Ribble Valley Borough Council

**App no: 25.0363**

**Address: Land off Pendle Street East Sabden BB7 9EQ**

**Proposal: Erection of 19 no affordable dwelling (100% affordable housing scheme) with associated car parking, landscaping and access from Pendle Street East, including demolition of existing domestic garages.**

SWEPT PATH ANALYSIS: REFUSE VEHICLE

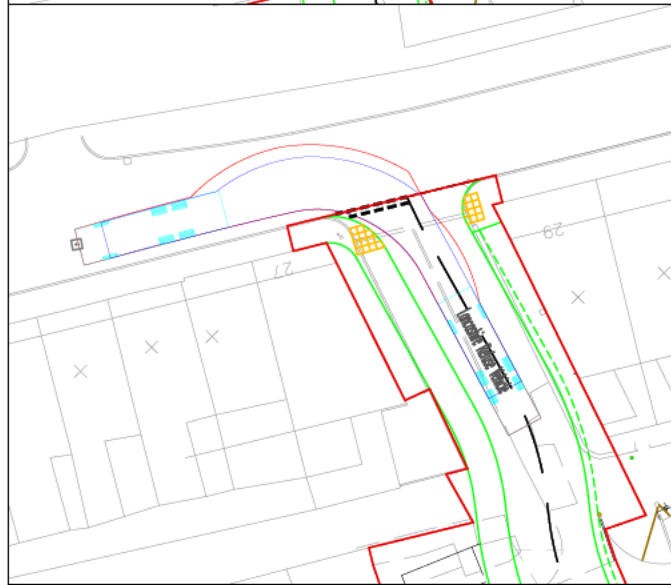
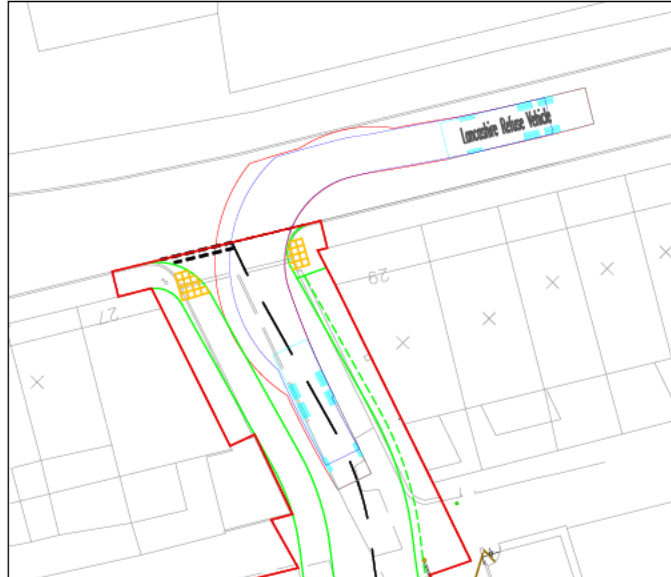
A swept path analysis for a 9.86m refuse vehicle is included in the Transport Note. Ribble Valley refuse team are currently running a 10.2m long vehicle however we would request tracking for the longest 11.2m vehicle to ensure it is futureproofed.
